CITY OF ALBUQUERQUE

RE: **Lot 21 Block 1 Volcano Cliffs SAD 227**
6905 Rimrock NW
Grading and Drainage Plan
Engineers Stamp Date 6/15/17 (D10D003D008)

Based upon the information provided in your submittal received 6/21/17, this plan is cannot be approved for Grading Permit until the following comments are addressed.

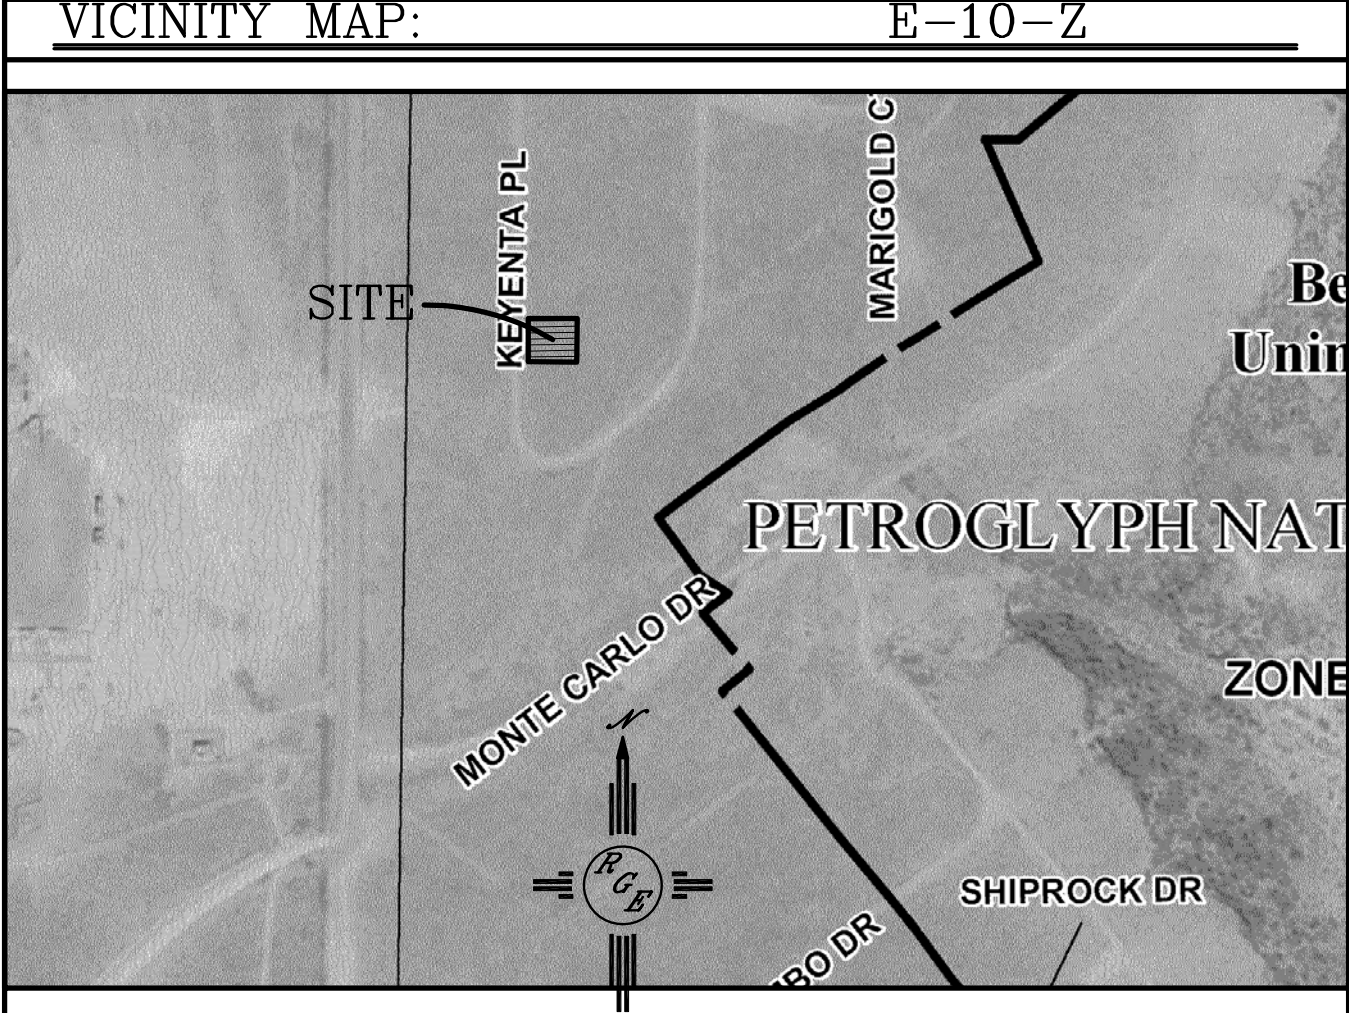
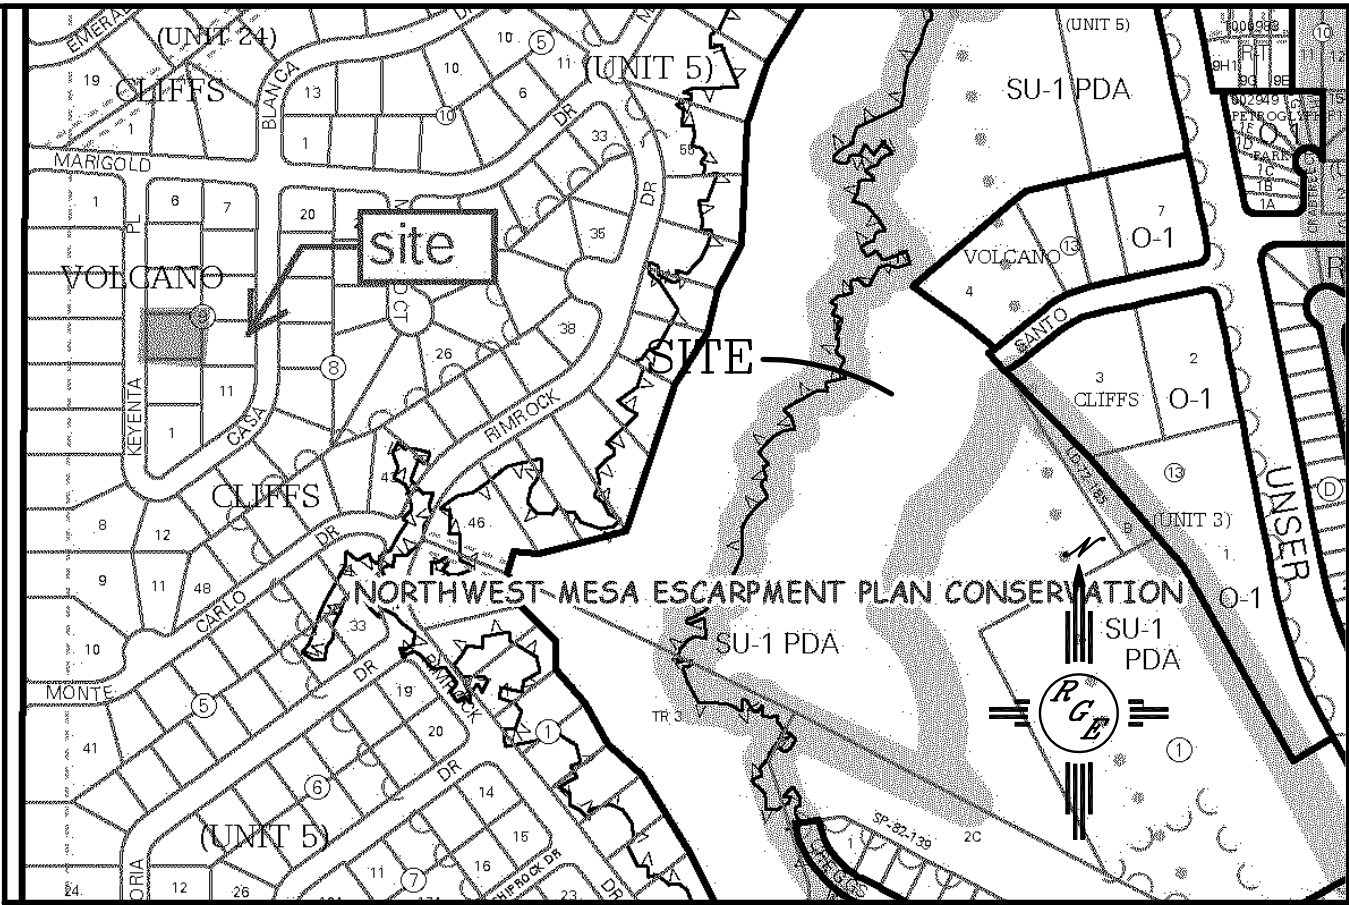
- Provide a statement on the plan that this grading plan must be used for the application of any garden/retaining walls.
- Provide a statement that a Pad Certification is required before building permit can be approved.
